Our ref: WA/2018/125145/01-L01
Your ref: 18/00484/OUT
Date: 22 May 2018

**Outline planning permission for up to 75 homes, pedestrian and cycle routes, creation of new access point from Charlotte Avenue, provision of open space, play space, allotments, orchard, parking and associated works
Land north and adjoining Home Farm, Banbury Road, B4100, Caversfield**

Environment Agency position

Appendix C Environment Agency JFLOW Data

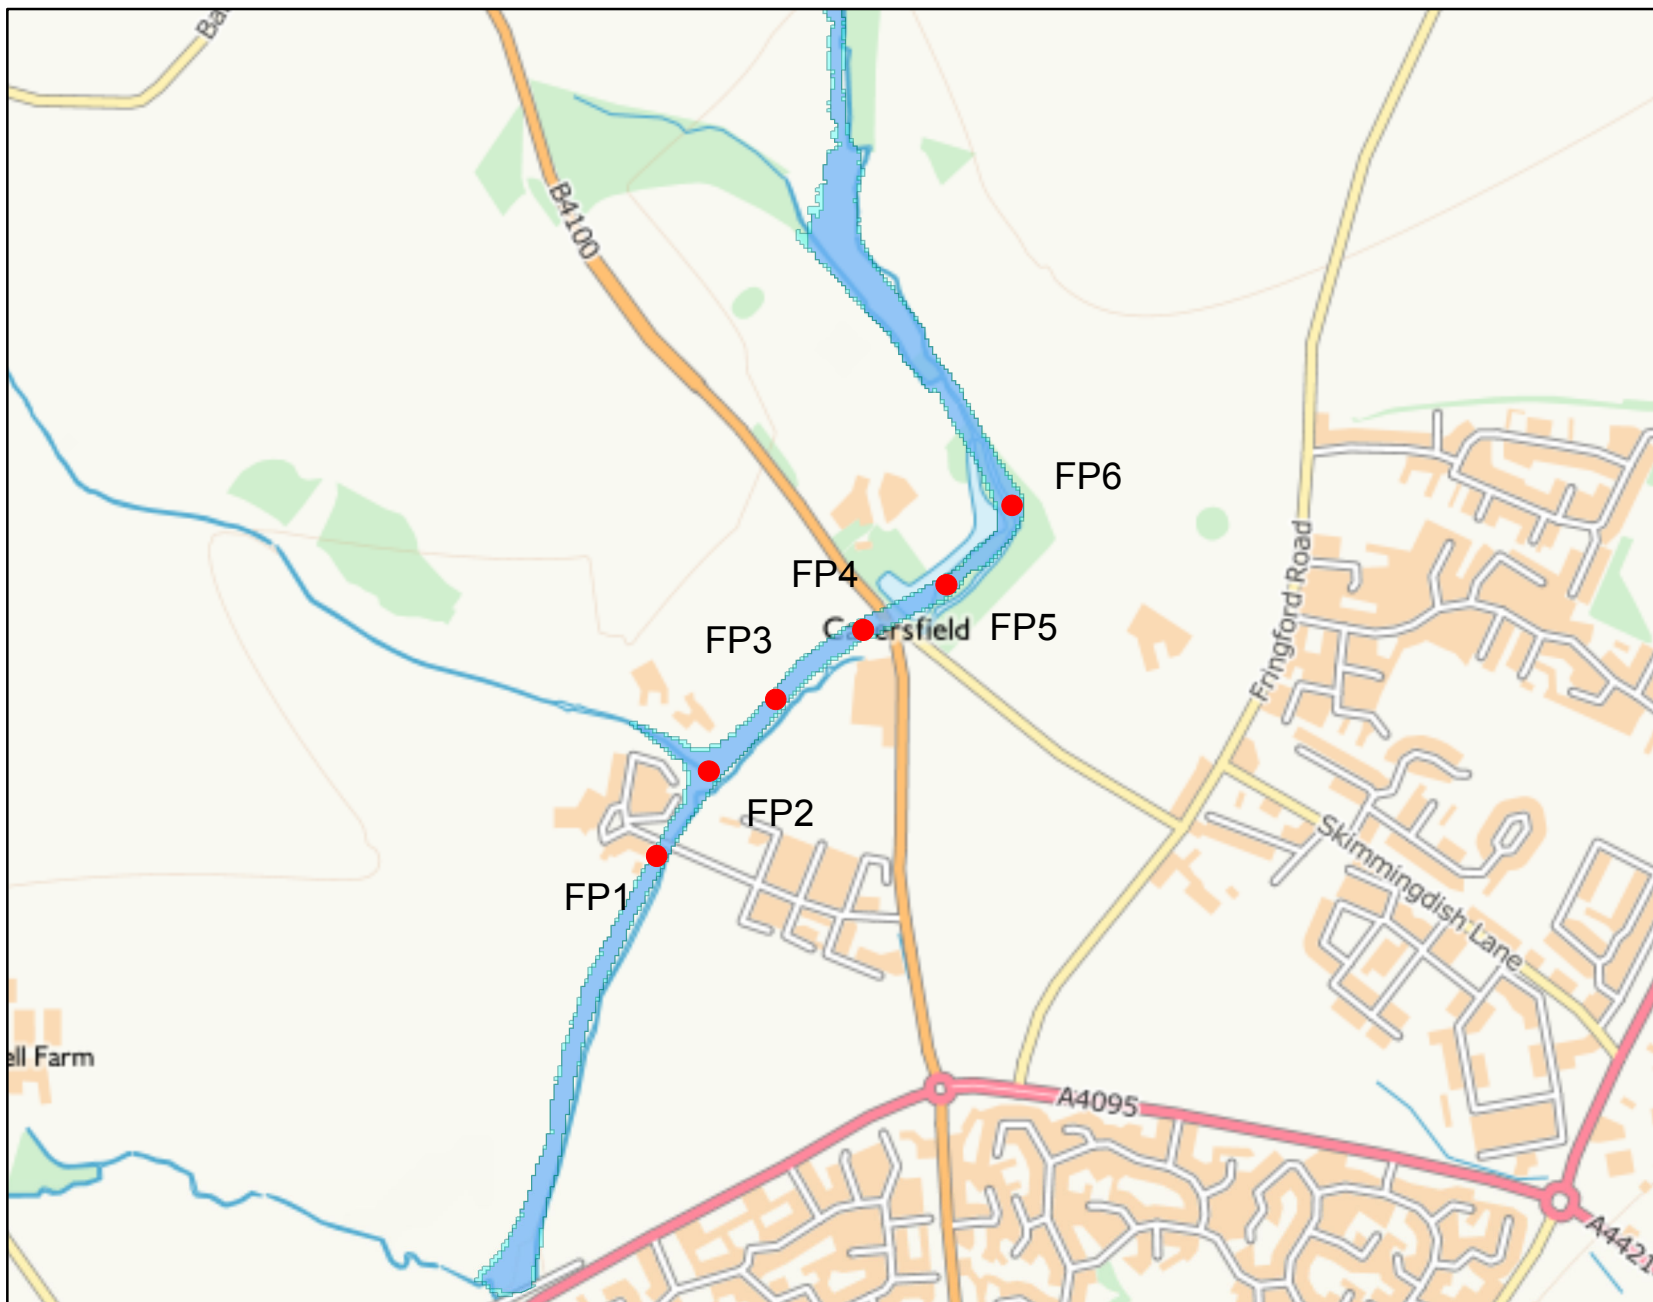
We understand that the proposed development is in Flood Zone 1. However although there is no detailed modelling of the site, the JFlow model is an indication that there would be flooding on the site boundary. Therefore a greater explanation of the flood risk on the site is required in order to establish the level of flood risk in relation to the proposed built development.

Specifically the FRA will need to demonstrate that the developed area of the site is not at risk of flooding, including an allowance for climate change. The assessment would need to demonstrate an understanding of the topography of the area, the flood plain, hydraulic structures which would have an impact on flow and the impact of the convergence of the two watercourses.
